Planning Application Ref: FP/227/20/T

Location: 49 Roundle Avenue, Felpham, PO22 8LJ

Description of works: Reduce crown of 1no. ash tree to height 9m and spread 6.5m

Photograph for Proposed Tree Works.

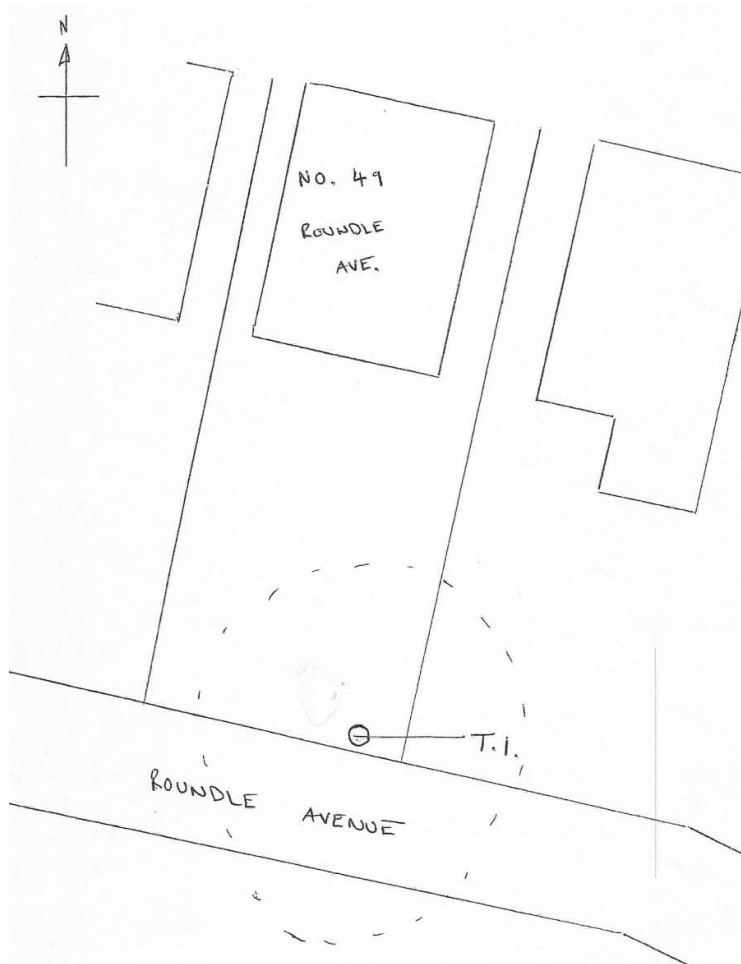
- The principle of whole crown-reduction pruning being sought here is acceptable given the history of management and past approval from the local planning authority. That said, the illustrated photograph showing 'suggested cutting position' of the scaffold limb tending towards the telegraph pole; exceeds the requirements of British Standard (BS3998:2010) Tree work – Recommendations and has not been justified.

- The telegraph pole is sited approximately 4metres from the stem base so leaving a radial crown spread of minimum 6.5m (is incompatible with the above proposed cutting position) rightly ensures enough small foliage-bearing branches can be retained to sustain the parent limb. The minimum 6.5m radial spread proposal takes precedence here.

- Part a) Where whole branches are to be removed and final cuts made close to the trunk or branch union they are to be made as shown in Figure 2 of BS3998:2010
- Part b) Where branches are to be shortened back the final cuts are to be made at the correct angle shown in BS3998:2010 and adjacent to a live bud or lateral.
- Part c) The removal of crown material which has developed since the last operation must be done sympathetically and with respect to established 'knuckles' so as not to extend beyond the point of origin.
